From: Olly Mayhew [REDACTED]
Sent: 04 November 2020 10:24
To: Nicola Moore; Amber Willard
Subject: Re: Further information - Y/122/20/NMA
Attachments: OM010_NMA_04.11.2020.pdf

From: Olly Mayhew <[REDACTED]>
Sent: 02 November 2020 09:43
To: Planning <[REDACTED]> Nicola Moore <[REDACTED]>; Amber Willard
<[REDACTED]>
Subject: Further information - Y/122/20/NMA

The original application for the single storey side extension was approved some time ago and this NMA relates only to the side extension.

Side Elevation Proposed (East)
Scale 1:100

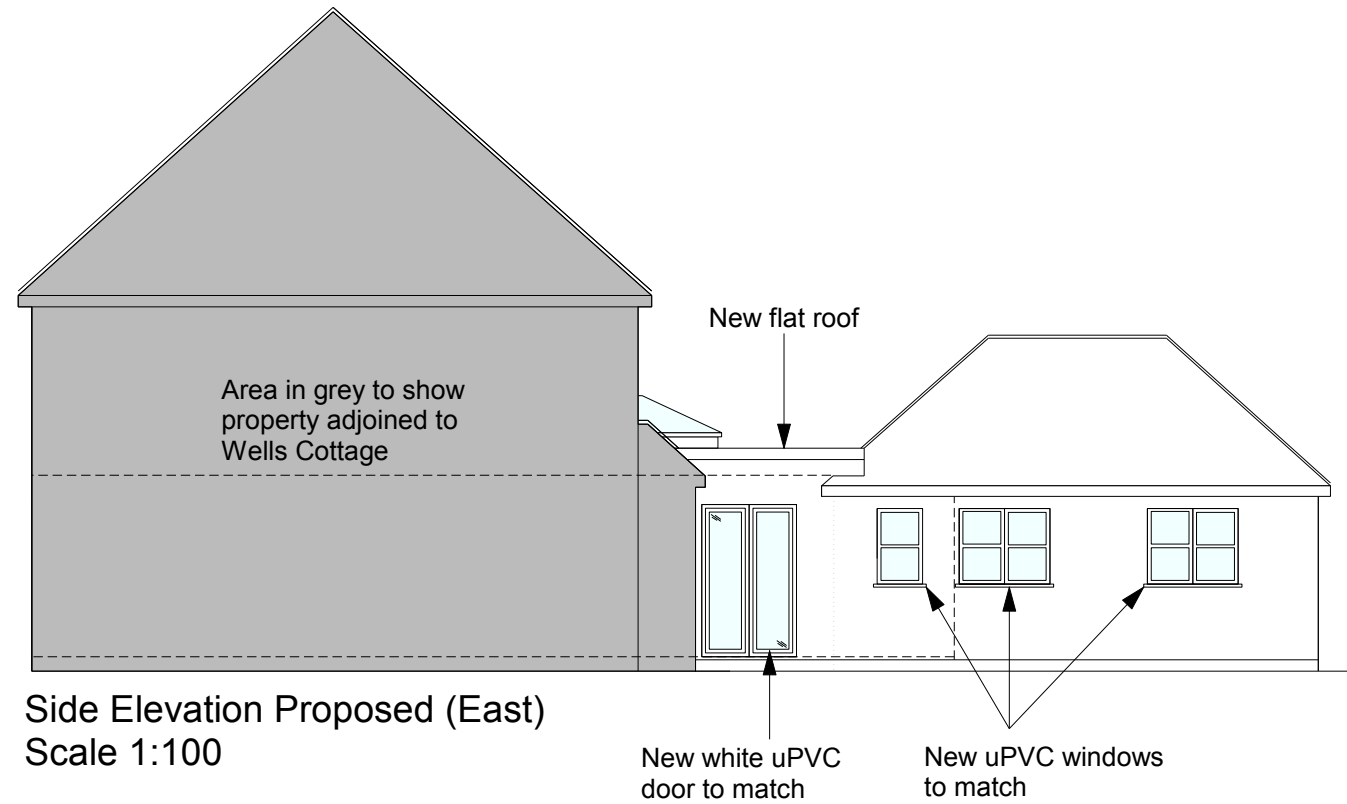
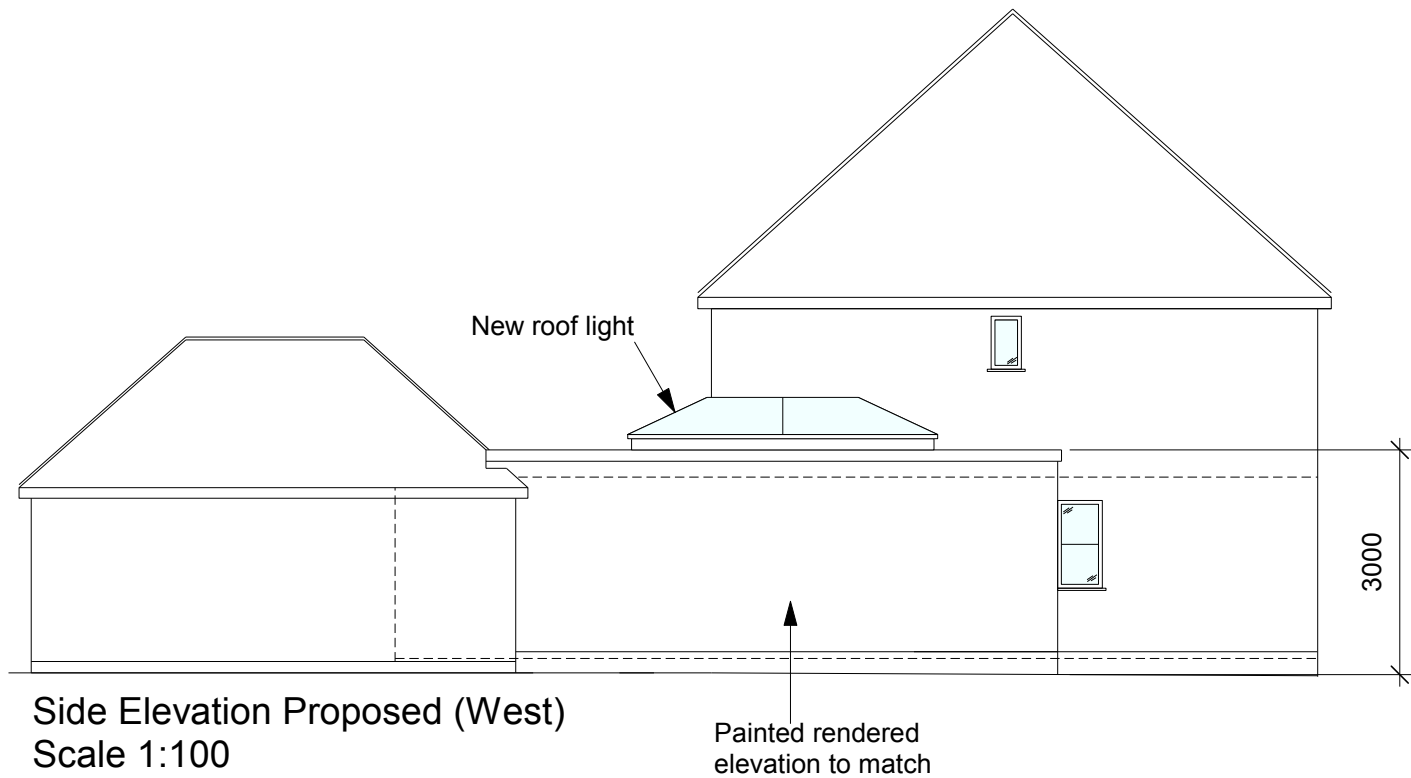
I have checked the Revised Extension plan (OM005 Rev B) and this does not appear to scale correctly as the new patio door at the front (East elevation) measures 0.66m at 1:100 but on Side Elevation plan (OM004 Rev B) it is 1.12m at 1:100.

The scale of the new patio door at the front (East elevation) will be the same as per the original proposal as we are only proposing we move the entrance back by approximately 1.3m to give a covered entrance porch.

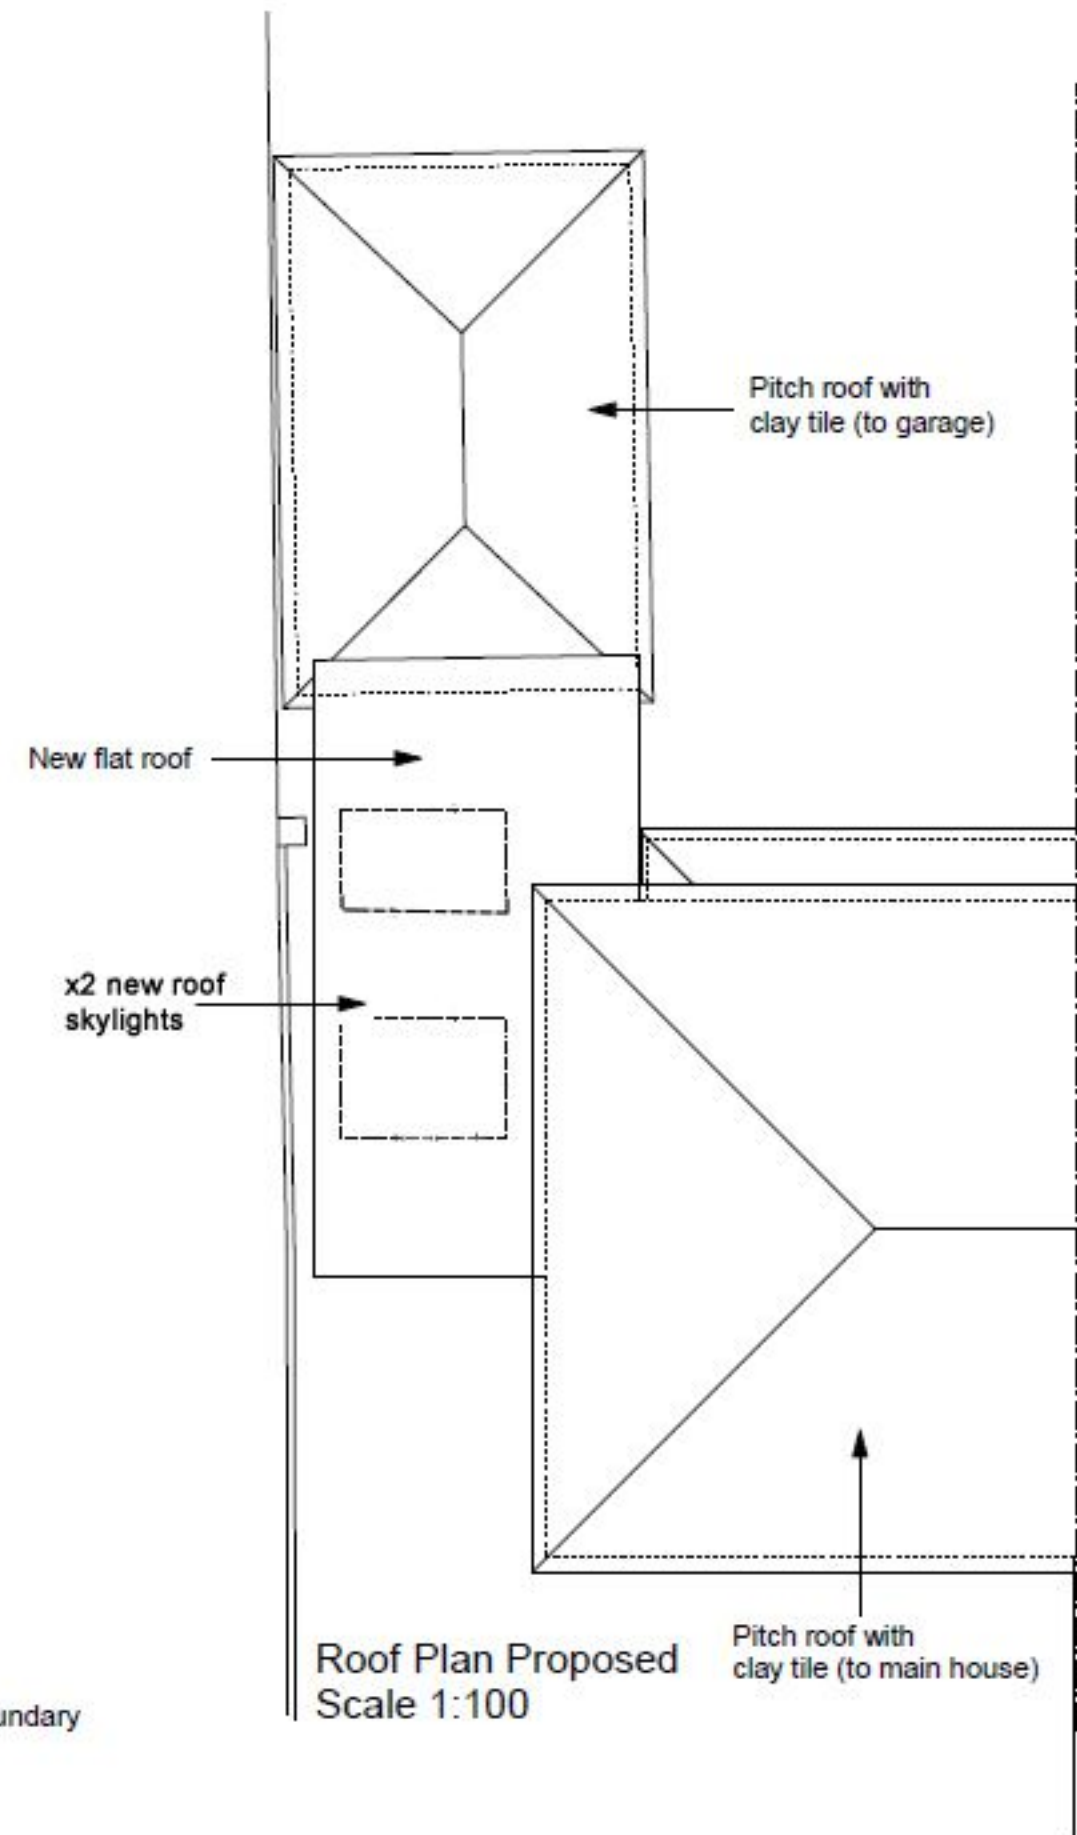
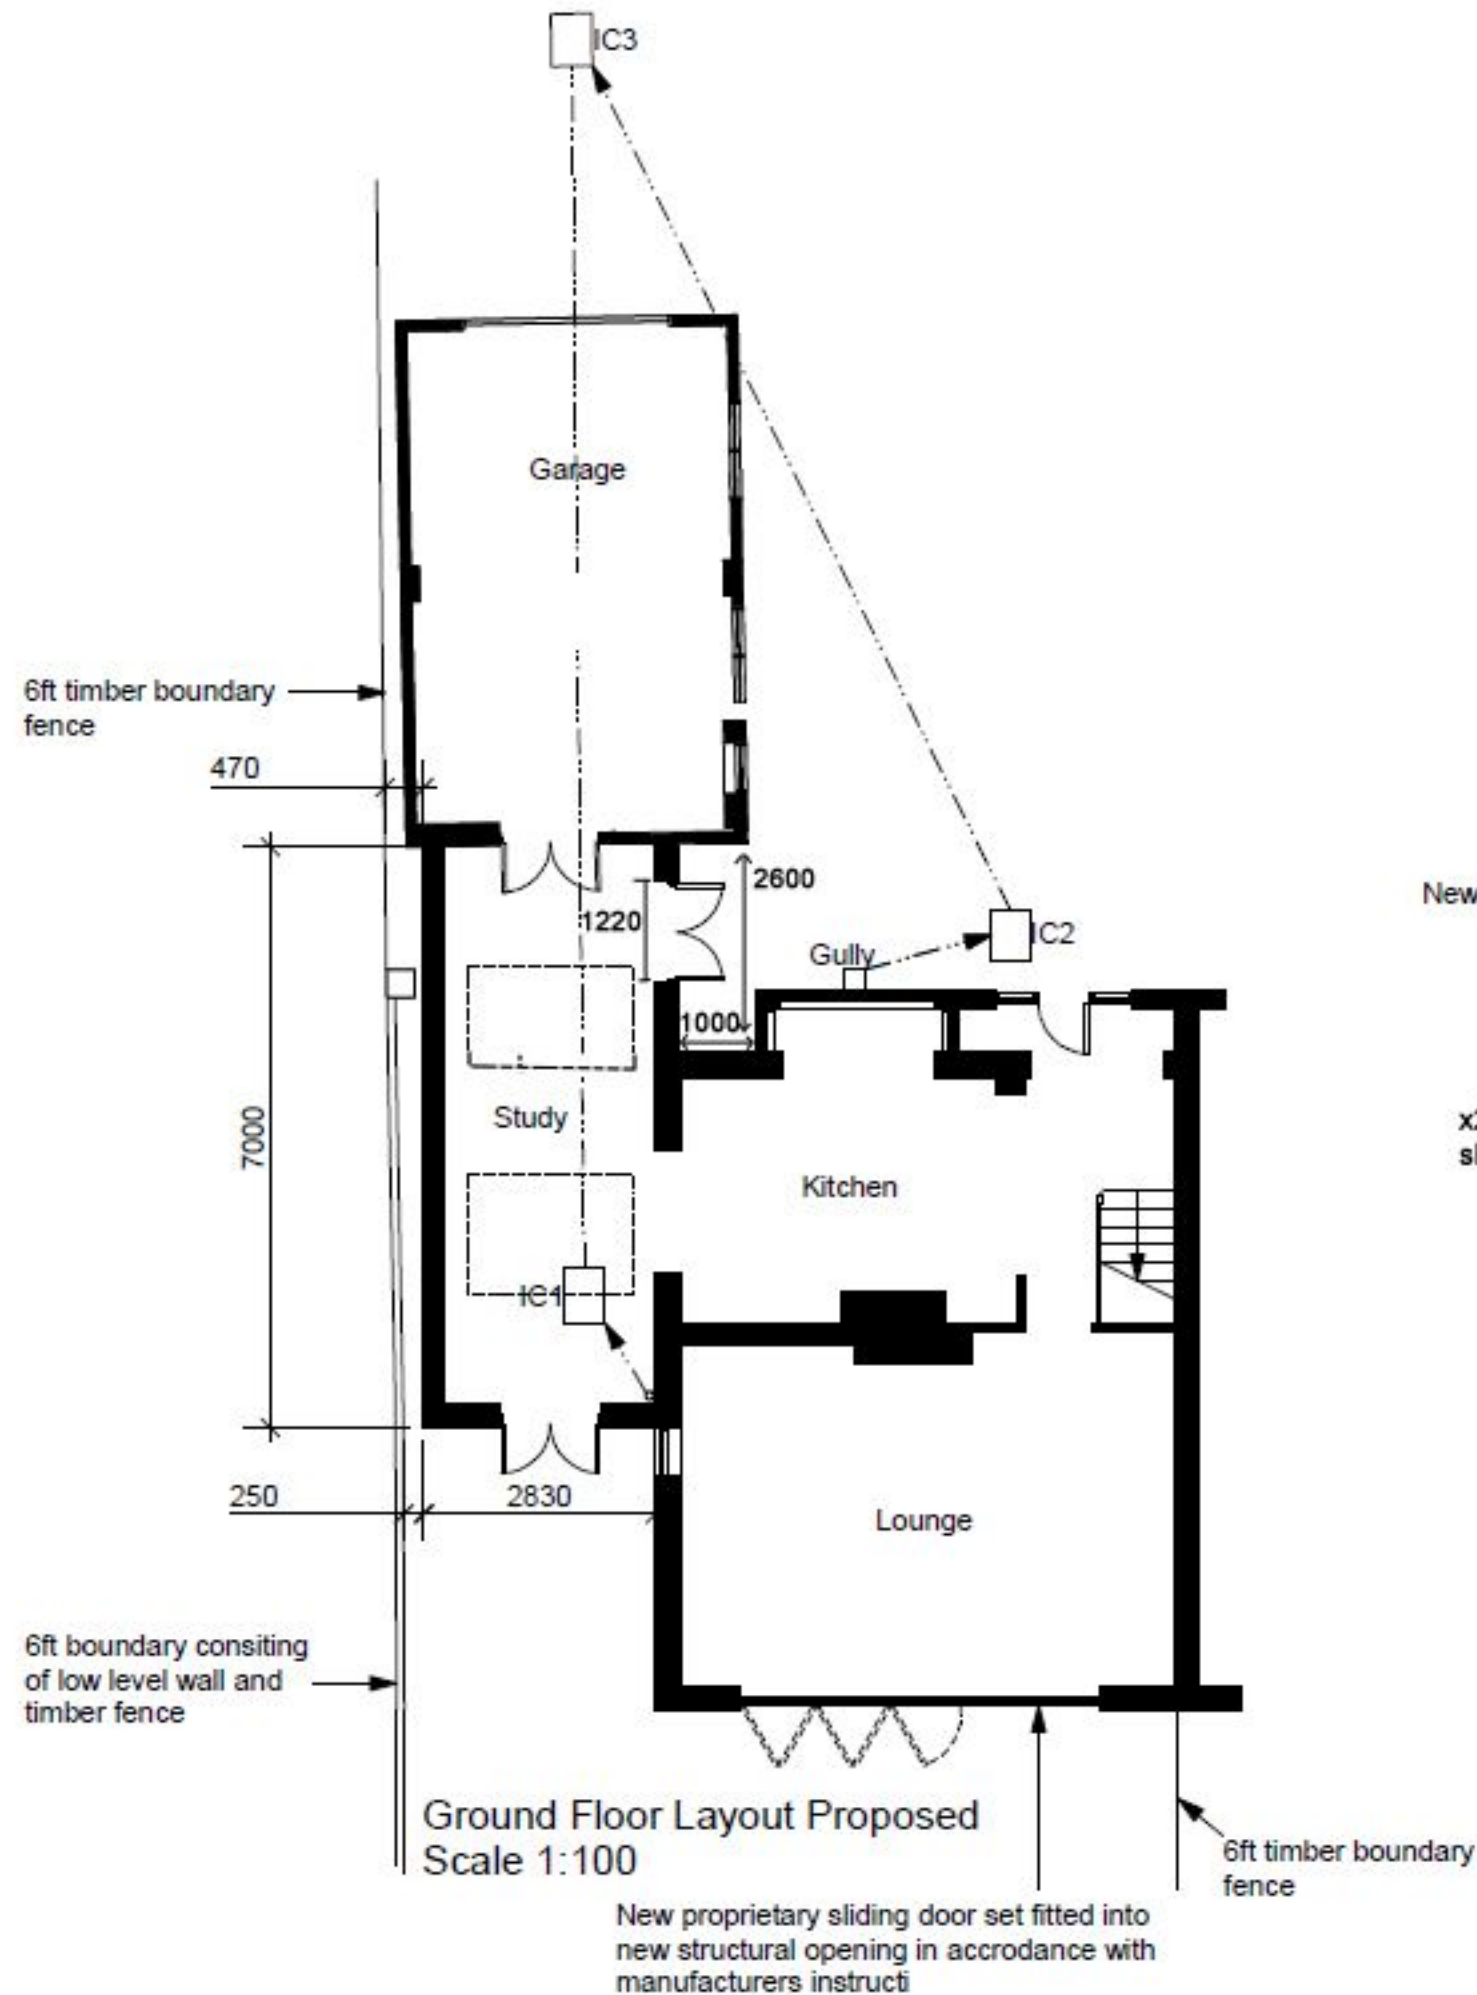
Also, the Revised Extension plan is titled and numbered the same as the approved drawing (OM005 Rev B). Please amend accordingly to ensure the plans are clear when uploaded on to our website.

Please see attached PDF of the revised plans. If the maximum adjustment is 1m then I will ensure this is applied. Please bear in mind, this adjustment will be a reduction in the floor plan but the original flat roof size will remain the same to give a covered entrance porch.

Changing the large single roof lantern to 2 much smaller, flat skylights thus reducing the overall height of the extension as the cost of the large roof lantern was prohibitive.

I have attached another document where I have updated the drawing number to OM010 and I hope this is satisfactory for you to now consider these minor alterations to the approved plans.

- Move the front (East elevation) wall and patio door back to be inline with the main west elevation of the house. The flat roof will not be altered in size to give a covered entrance porch.
- Change the single, large roof lantern to two smaller pano roof skylights.
- Brick up the garage window on the south elevation as we no longer require a new door to the garage.
- Disregard the extension into the garage for a w/c at this time.
